BUILDING CODE OF AUSTRALIA REPORT

Proposed Industrial Development

5-9 Culverston Road, Minto NSW

As Accredited Certifiers, we have reviewed architectural design documents prepared by Reid Campbell (refer appendix A) for compliance with the Building Code of Australia 2015.

Drawing Title	SITE MASTERPLAN (OVERALL)
Drawing Number	116101_A_SSD_A0006
Issue	7

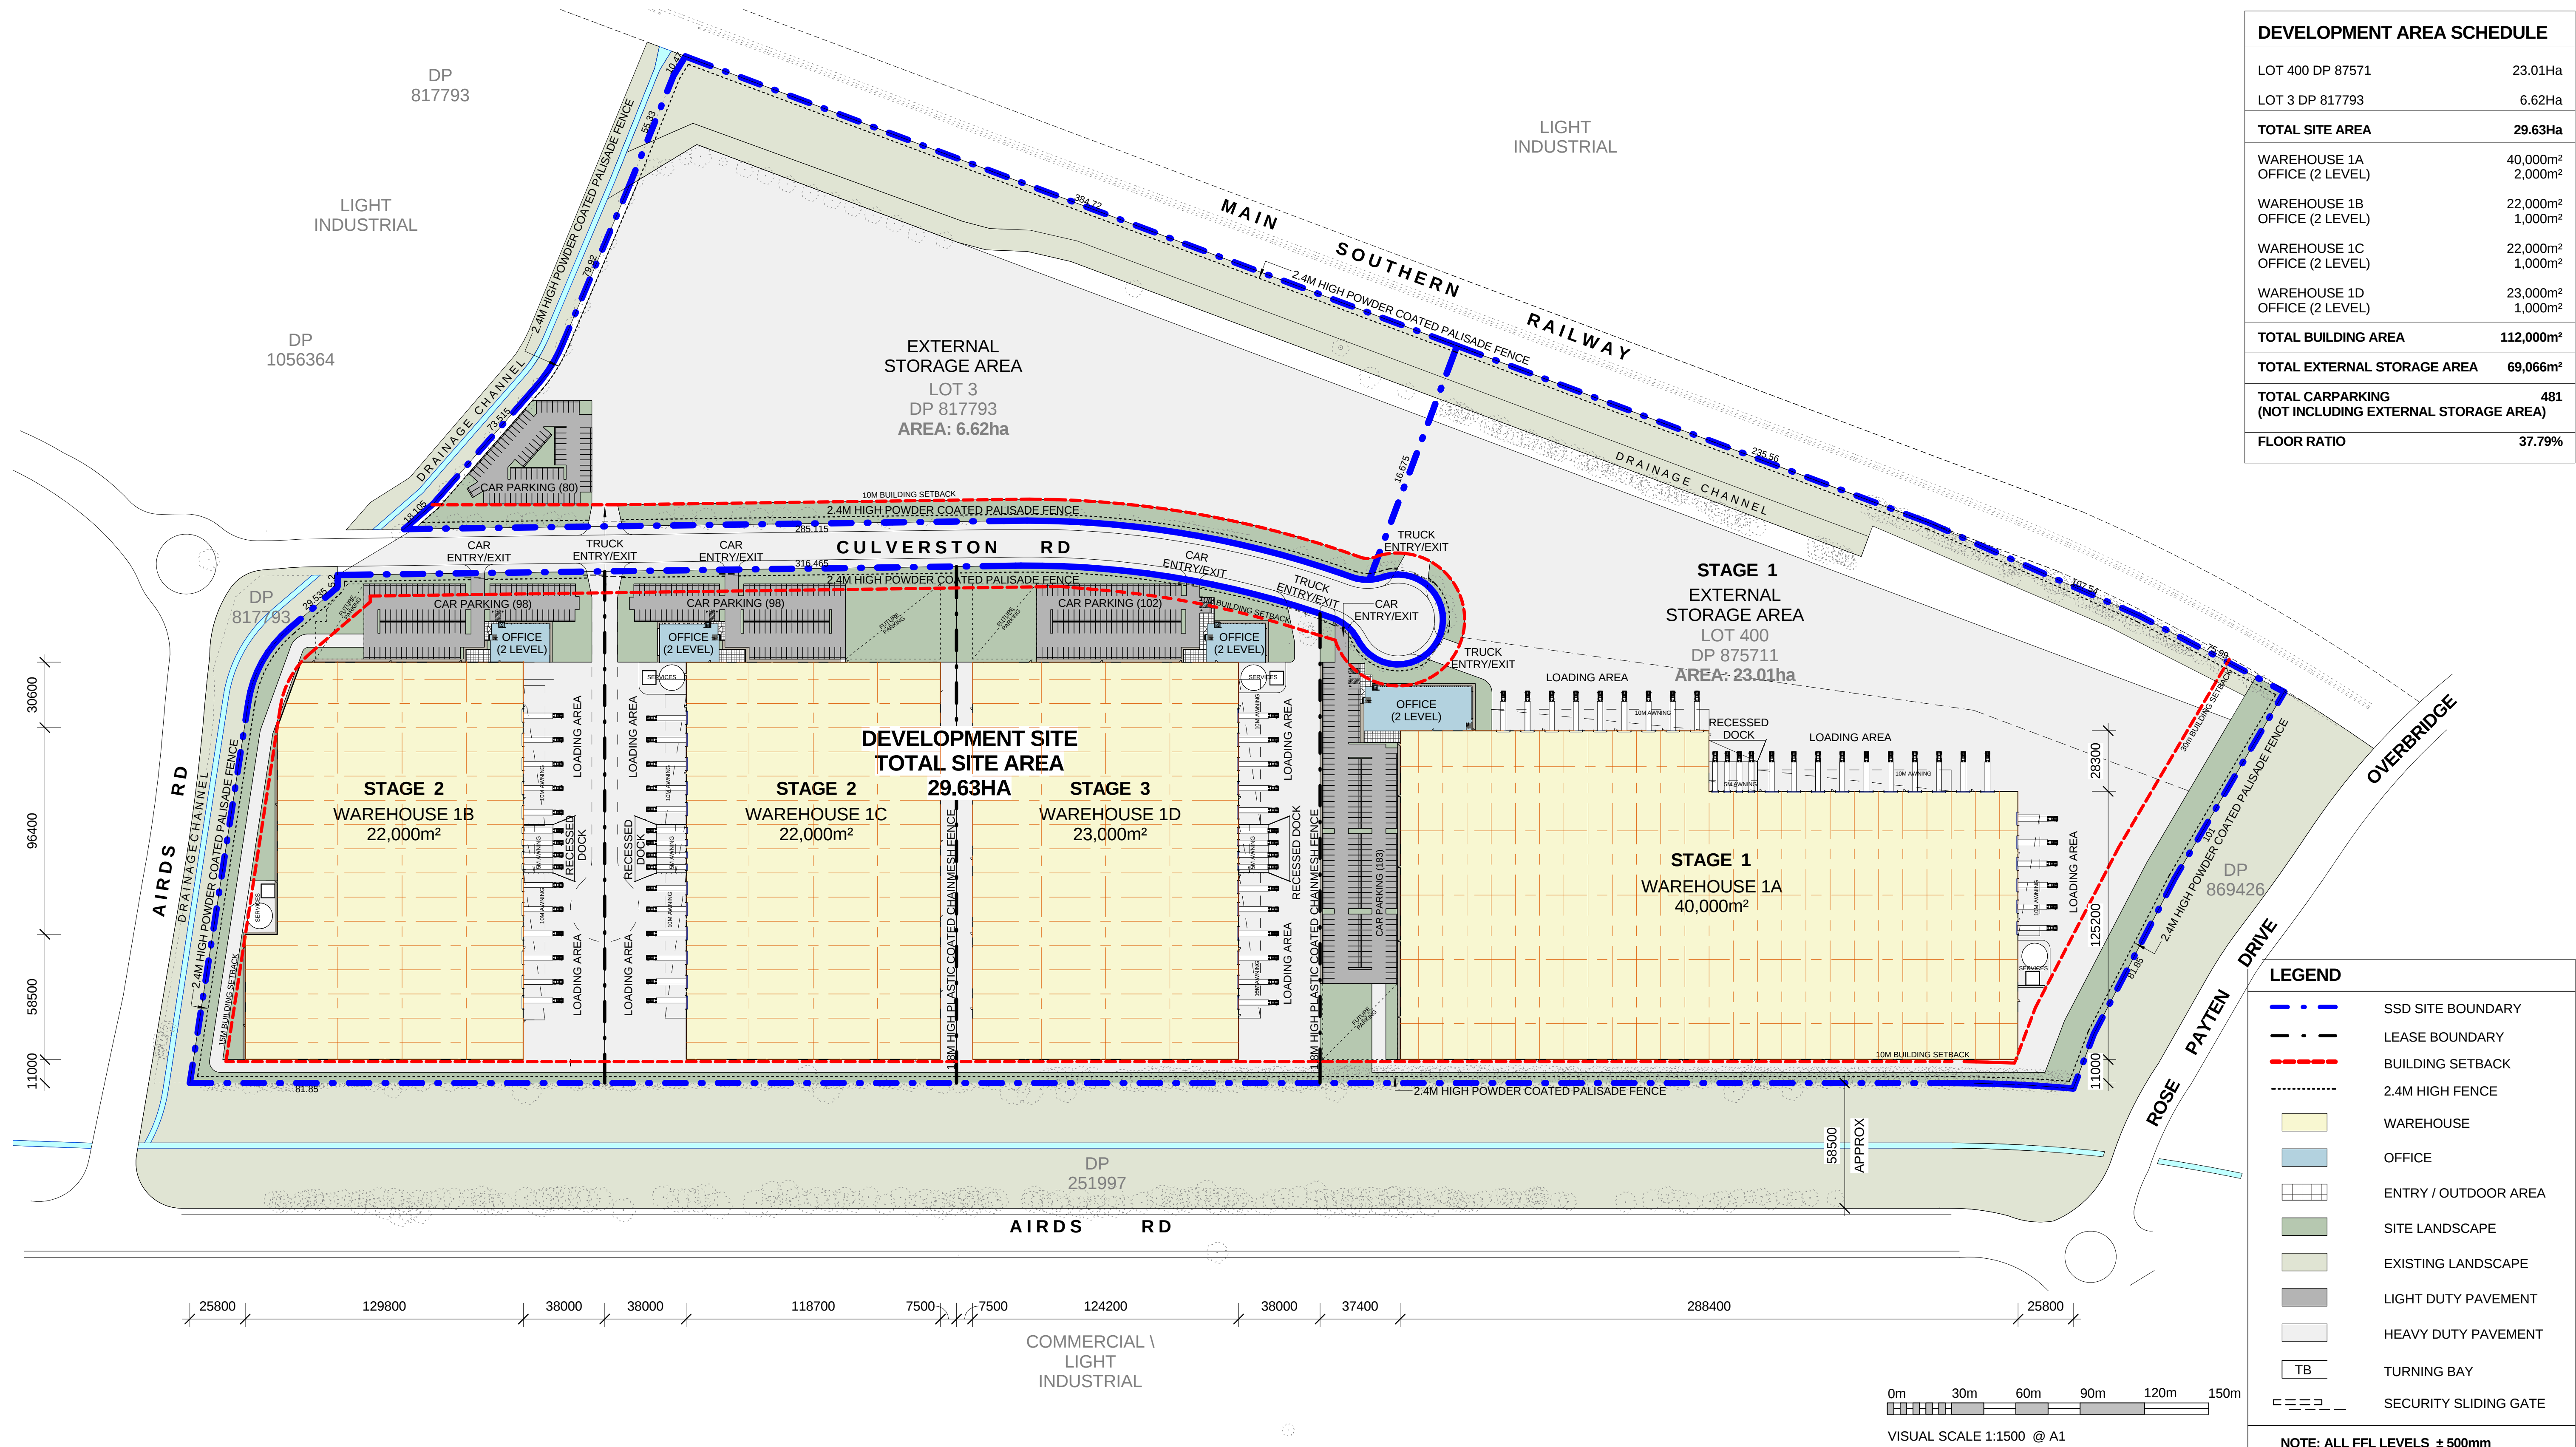
DTS Clause	Description of Non-Compliance	Performance Requirement
C2.3	<u>Warehouse 1A</u> Emergency vehicular access will be required to be assessed as part of the fire engineered solution as access for emergency vehicles has been provided to Eastern, Southern & Western sides in lieu of the entire building.	CP9
D1.4	Travel distances are to be addressed through the development of an alternative solution by an Accredited Fire Engineer and verified against the Performance Requirements of the BCA.	DP4 & EP2.2
E1.3	Hydrants located under an awning, (and used as an external hydrant for the purposed of coverage) will be required to be included within the fire engineered solution prepared by an Accredited Fire Engineer and verified against the Performance Requirements of the BCA.	EP1.3
E2.2	Smoke hazard management to the development is to be assessed at part of the Fire Engineered Solution prepared by an Accredited Fire Engineer and verified against the Performance Requirements of the BCA.	EP2.2

The fire brigade perimeter access will be required to be assessed as part of the fire engineered solution for the development as continuous access for emergency vehicles in a forward direction has not been provided to Warehouse 1A due to the car parking located on the Northern elevation, assessment against performance requirement CP9 of the BCA is required.
